City of Albuquerque Stormwater Construction Site Inspection Report

General Information					
ESC File No.	K09E051	Project Name:	Titan (Spec) 150K		
NPDES Id. No.	NMR1004R6	Location:	Daytona and Bluewater Rd		
8/2/2023	Owner		Contractor		
Operator	Westpoint 40, LLC		Wilger Construction		
Contact name & title	Brian Patterson		Tim Lindgren		
e-mail	bpatterson@titan-development.com		tlindgren@wilger.com		
Contact Phone #	505-998-0163		505-239-0246		
COA Inspector	Chancellor English		Start/End Time:	11:30am	
Construction Phase:	Paving, landscaping, interior				
Type of Inspection:	<input type="checkbox"/> Regular	<input type="checkbox"/> Storm Event	<input type="checkbox"/> Post Storm Event >0.25"	<input type="checkbox"/> 311/Complaint	<input checked="" type="checkbox"/> Follow Up
Weather at time of inspection?	Clear		Temperature: ~	95	
Estimated date of last storm 0.25" or greater	5/22/2023

SEDIMENTATION/SILT FENCE WITH WIRE SUPPORT (SF)

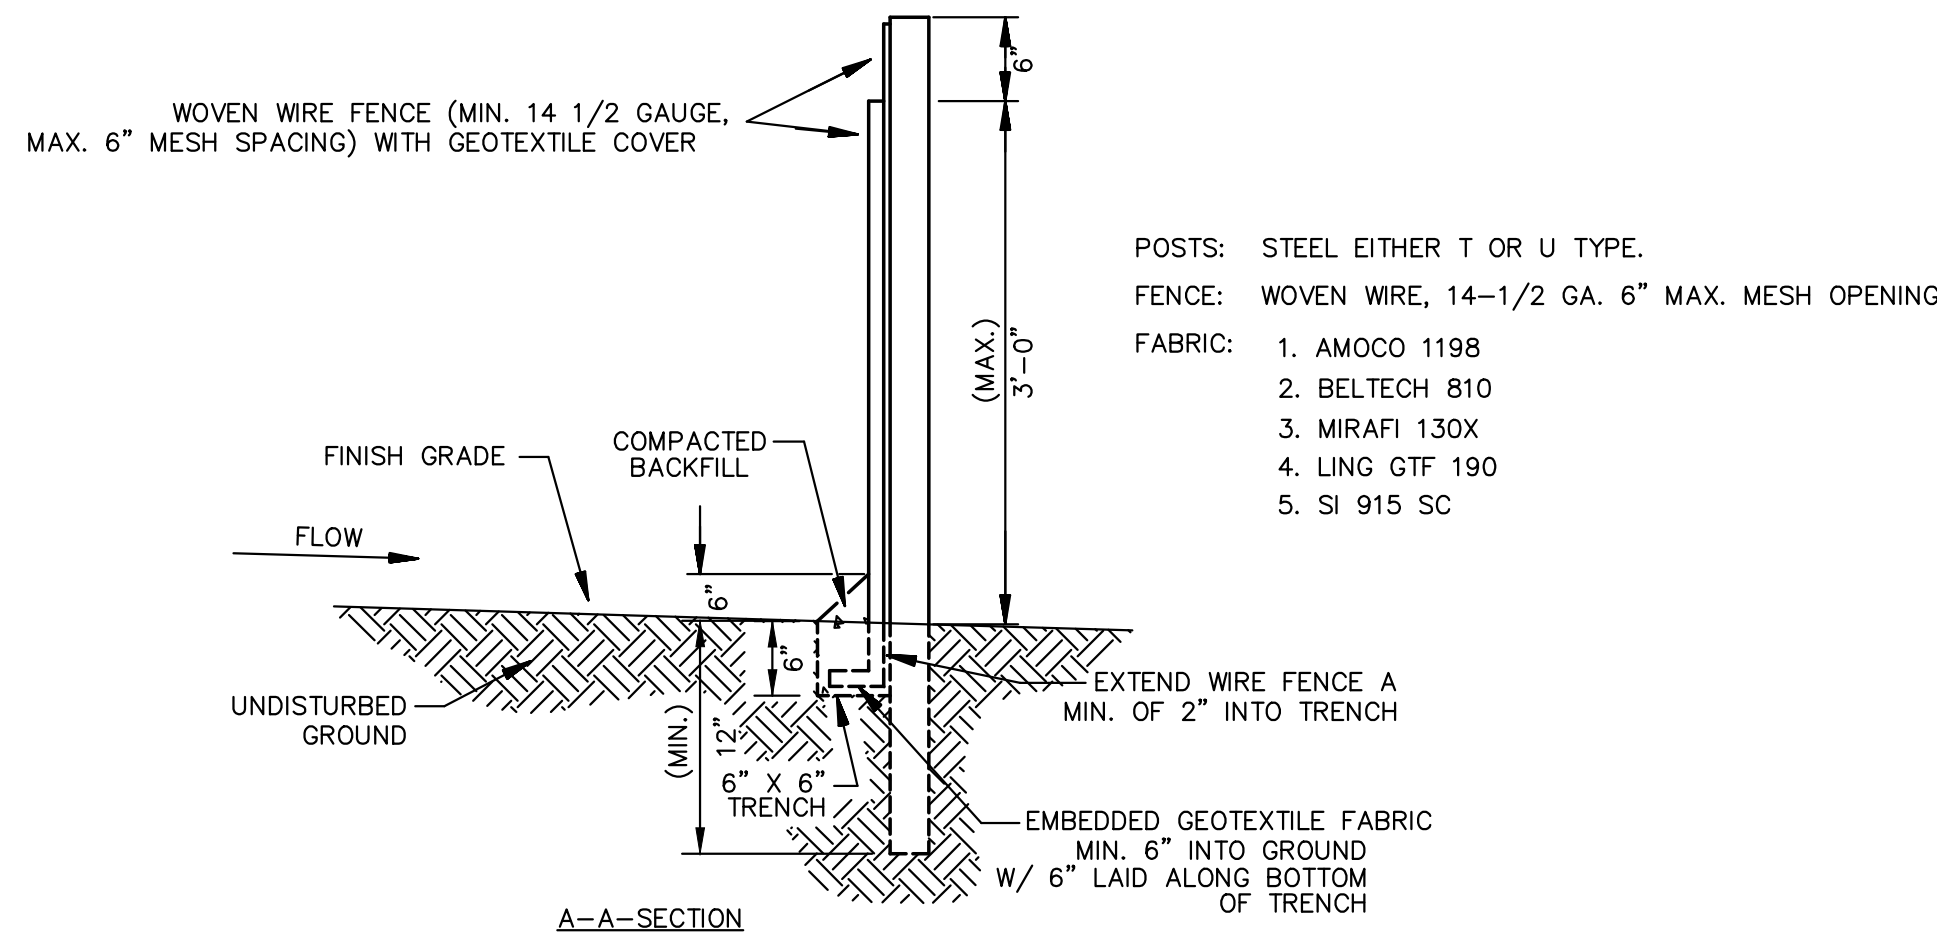
Item Number	Deficiency/ Corrective Action				
1	BMPs in need of repair. The silt fence along Daytona Road needs to be re-staked. Required mitigation: Ensure all stormwater controls are maintained and remain in effective operating condition during permit coverage and are protected from activities that would reduce their effectiveness as per CGP Part 2.1.4.				
2	The pond on the east side of the southern lot is partially stabilized. The southern lot and northern lot disturbances require stabilization that should be initiated if construction activities have permanently ceased or will be inactive for 14 or more calendar days. Required mitigation: Complete the pond and southern lot stabilization as required in CGP Part 2.2.14.				
3	A dirt ramp was found on the corner of Daytona Road and Bluewater Road. This ramp is located directly next to a stormwater curb inlet. The inlet protection needs repair. The City does not allow dirt ramps of any kind. Required mitigation: You must minimize track-out and use appropriate stabilization techniques at all points that exit onto paved roads, per CGP Part 2.2.4. You must protect storm inlets per CGP Part 2.2.10.

2.1	Discharge off site? (Y/N)	No			
4	Self Inspection Reports	Yes	Latest report Date:	7/13/2023	
Notes:	Tim has SWPPP inside building				
Previous inspection found out-of-date SWPPP and missing inspection reports (some issues with SWPPP were resolved), BMP maintenance/repair, and NOI posting. The silt fence on the west side of Daytona has been damaged by wind and/or vehicles twice.
